MEMORANDUM

Subject: **Raising Cane's South Half of 2004 Wyoming Blvd NE**
Erosion and Sediment Control Plan
Engineer's Stamp Date 8/9/2022 (H20E003D)

The intent of this memo is to provide responses to the Erosion and Sediment Control Plan of the Project Raising Cane's 2004 Wyoming Blvd. Southern Parcel, submitted to One Albuquerque Planning. Please find the corrections listed below with our response to corrections in **bold**.

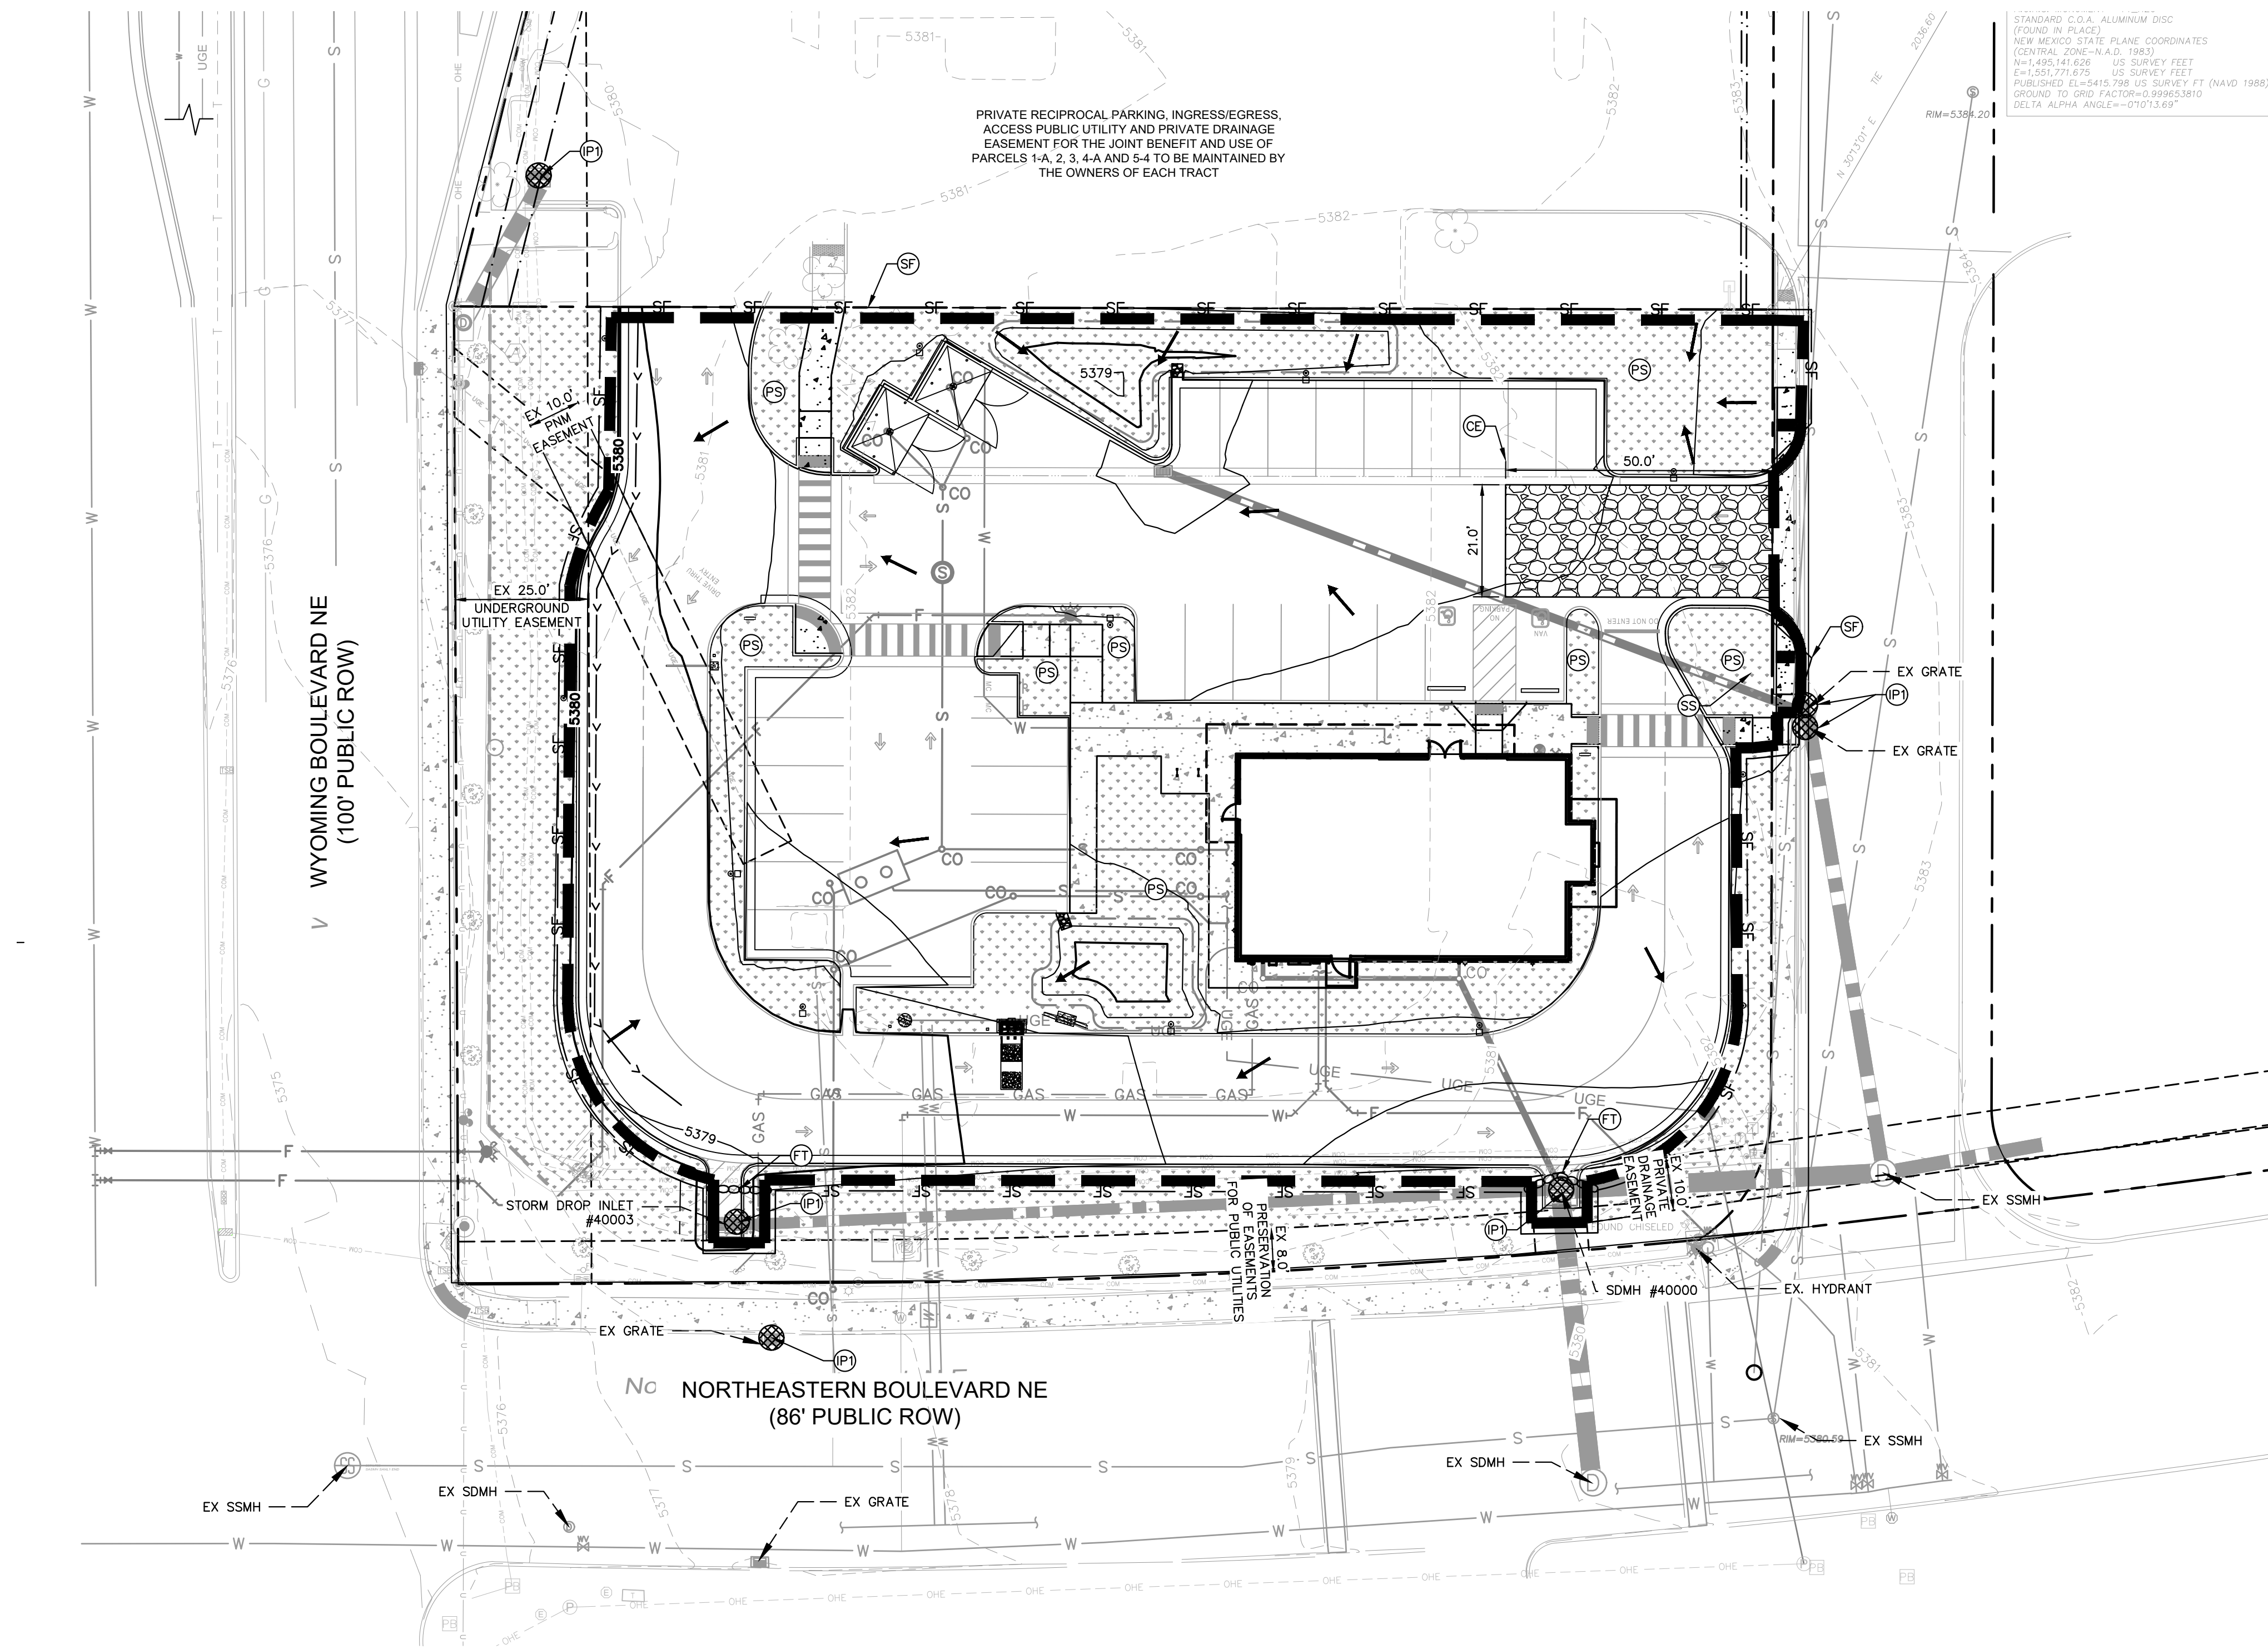
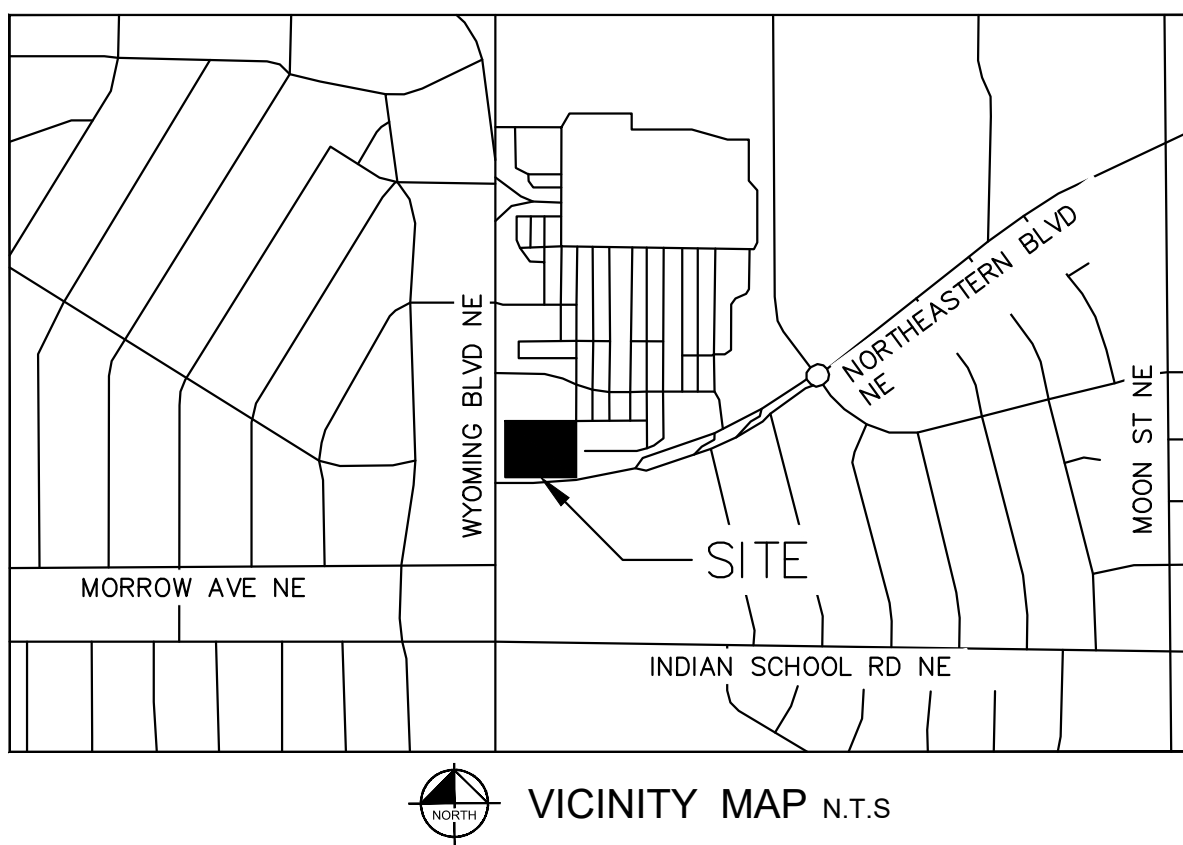
2. Silt fence must extend around the entire area of land disturbing activities.

The silt fence has been extended. See sheet C3.0 for update.
